From: Mundy, Ben - Oxfordshire County Council <Ben.Mundy@Oxfordshire.gov.uk>
Sent: 25 November 2022 15:49
To: Michael Sackey; DC Support
Cc: Transport CDC Minor
Subject: 22/03385/DISC The Beeches, Heyford Road, Steeple Aston, OX25 4SN

Condition 8:

Condition 10:

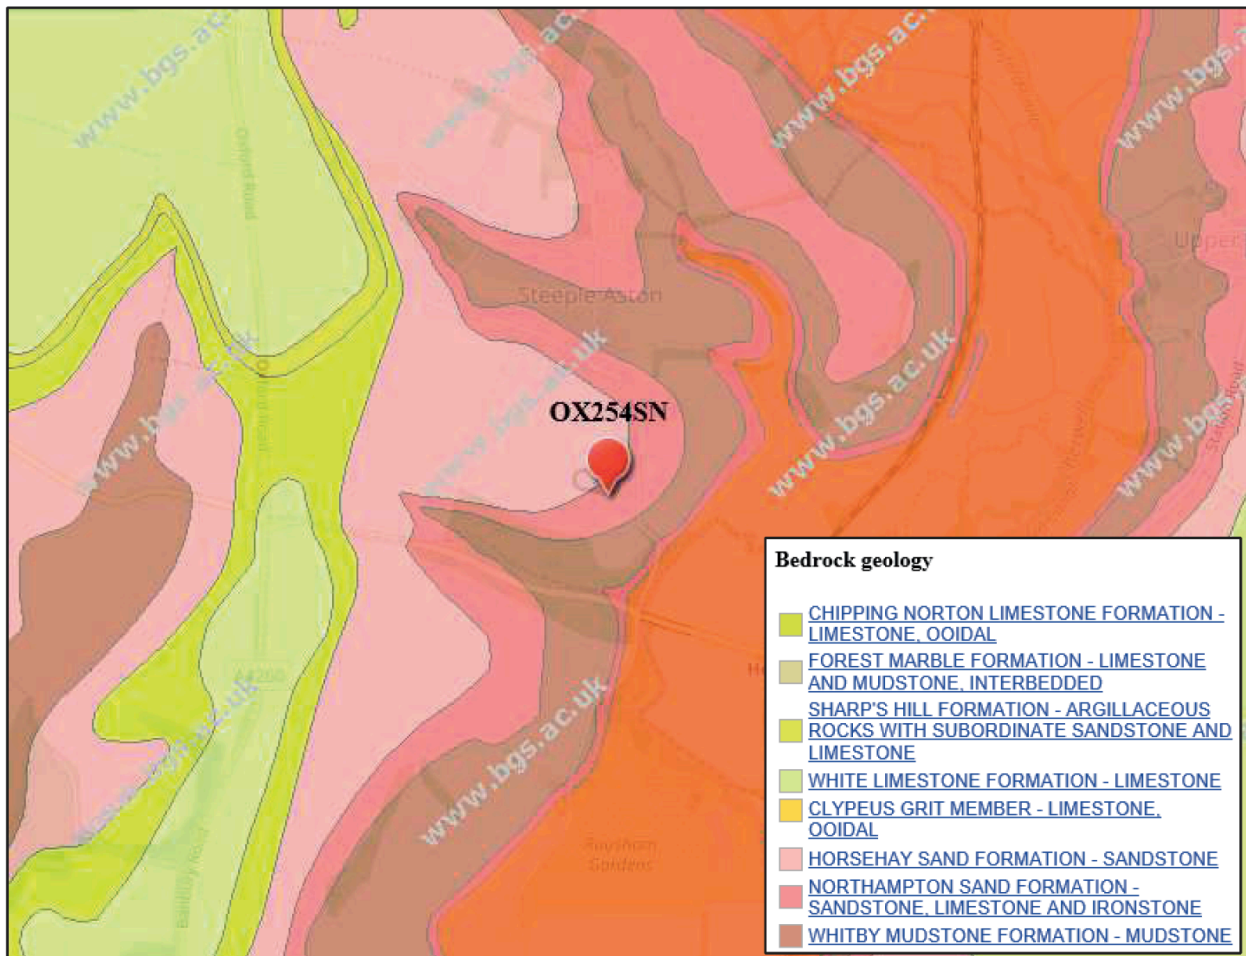
There have been no diagrams detailing specific cycle parking arrangements, however plans show that the existing garage is being retained. Garages are considered an acceptable form of cycle parking.
